RE: MOUNT PLEASANT OPERATION (DA 92/97 MOD 3) – REQUEST FOR ADDITIONAL INFORMATION

In response to the Department's letter dated 22 December 2017 requesting additional information on MACH Energy Australia's (MACH Energy's) proposed Mine Optimisation Modification (Modification 3), we have responded in the same order raised in the Department's request.

**MACHEnergy**  
MOUNT PLEASANT OPERATION  
Evening P10 Intrusive  
 $L_{Aeq}$  (15 minute) Noise Contours -  
2018 and Revised Noise Assessment Groups

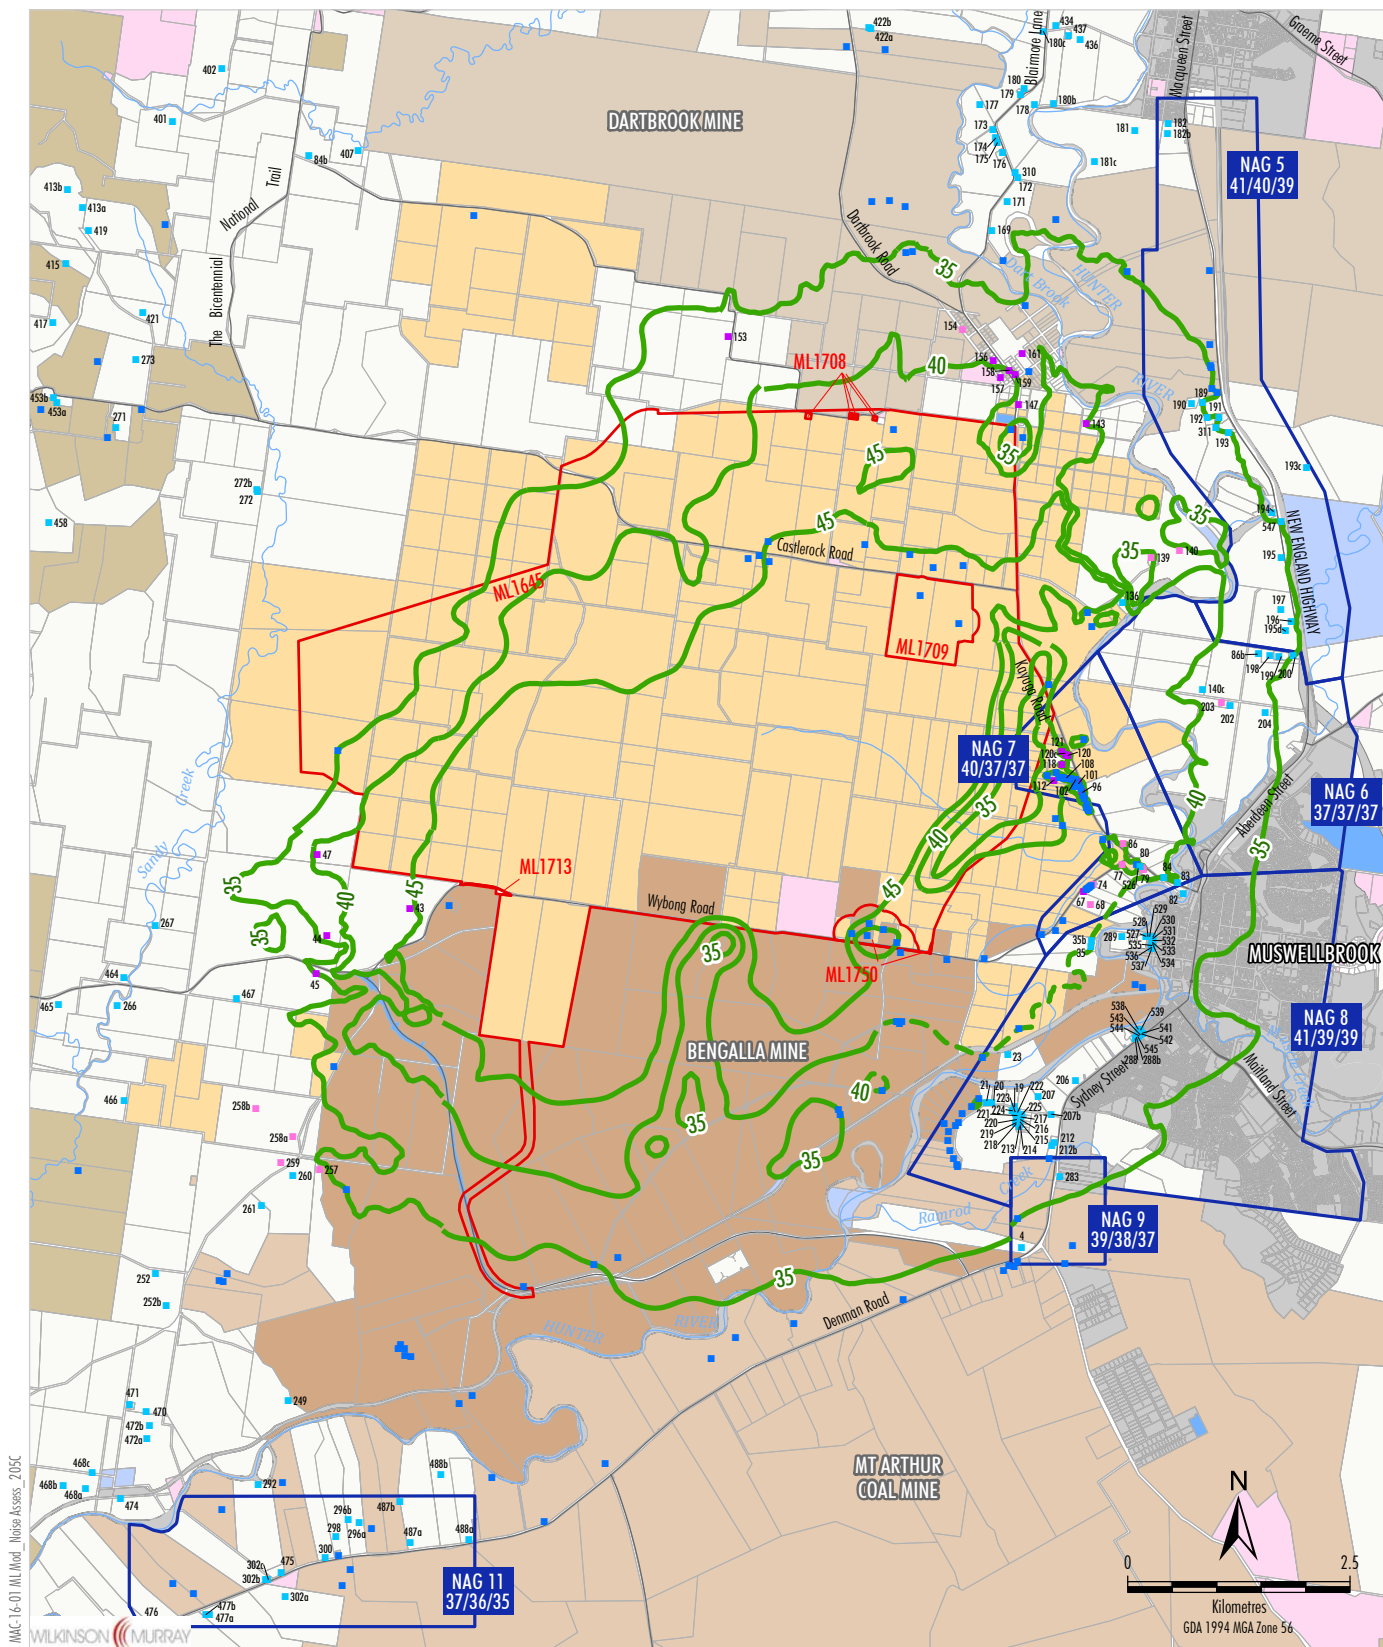
The Environmental Assessment (EA) identifies that the delineation of noise assessment groups (NAGs) has been amended relative to the existing approved project. The Department does not consider that sufficient justification has been provided for the proposed changes in NAGs, which would increase the existing noise criteria applicable to a substantial number of properties. Further, the Department is not yet convinced that all of the proposed extensions to existing NAG boundaries are reflective of background levels in these locations.

I also note that the proposed NAG boundaries appear to cover a broad range of predicted noise levels, for example NAG 8 includes predicted impacts ranging between 45 dB in the west to less than 35 dB in the east. Given this range of predicted impacts, the Department is unlikely to recommend the application of uniform noise criteria for all residents within these areas, especially in areas such as east Muswellbrook where the project is predicted to meet lower noise limits. I would therefore request that further consideration is given to the refinement and differentiation of receivers within NAGs (especially NAGs 6, 7 and 8).

Wilkinson Murray's (2017) proposed revisions to the NAGs address some identified limitations/issues with the previously consented NAG boundaries.

In summary these were (Figure 1):

- A number of the NAGs were redundant (i.e. NAGs 1, 2, 3, 4 and 10).
- Minor adjustment to NAG 5 and 11 boundaries to include additional proximal residences identified by MACH Energy's new dwelling verification along major transport corridors.
- Adjust NAG 6 and 8 eastern boundaries to better reflect land use where the previous NAG had an arbitrary boundary bisecting the town of Muswellbrook.
- Some other minor changes to better reflect local property boundaries.
